Application for a non-material amendment following a grant of planning permission. Town and Country Planning Act 1990

Erection of a first floor side extension and single storey rear extension. Conversion of garage to provide additional living accommodation.

DC/20/04627

PROPOSED ELEVATIONS.  
1:100 AT A3.

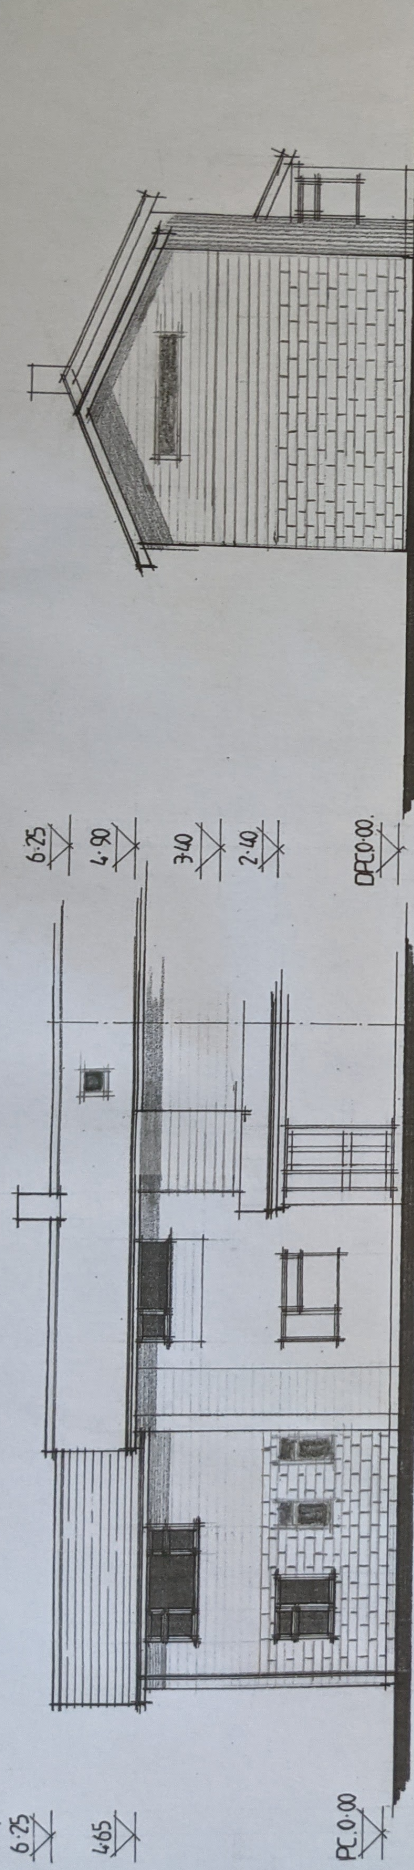
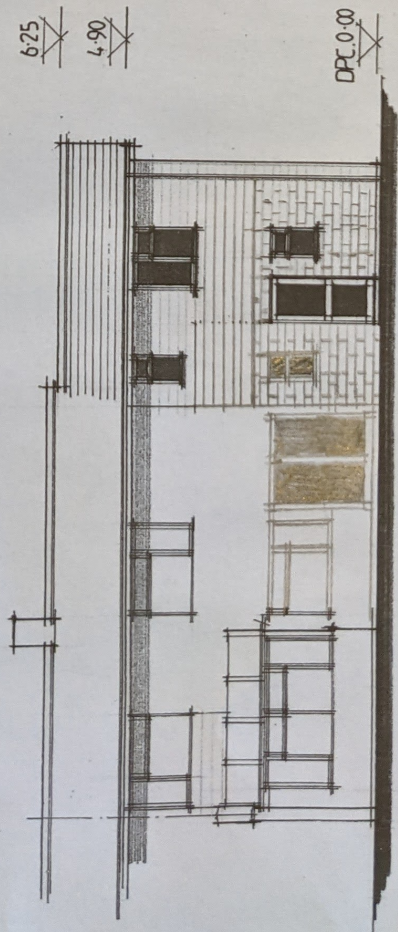
- No longer require single storey extension to rear of property
- Redesign of current garage space to toilet and larger utility space (removal of shower room) - alters window layout to front and side of property - see new drawings.
- Upstairs no longer requiring window above stairs (this window is not currently there anyway) proposed sun tunnel on roof instead - see new drawings
- Master bedroom redesign side windows to pillarbox style single window - see new drawings.
- Cladding (eg Hardiplank) to only be applied to first floor extension.
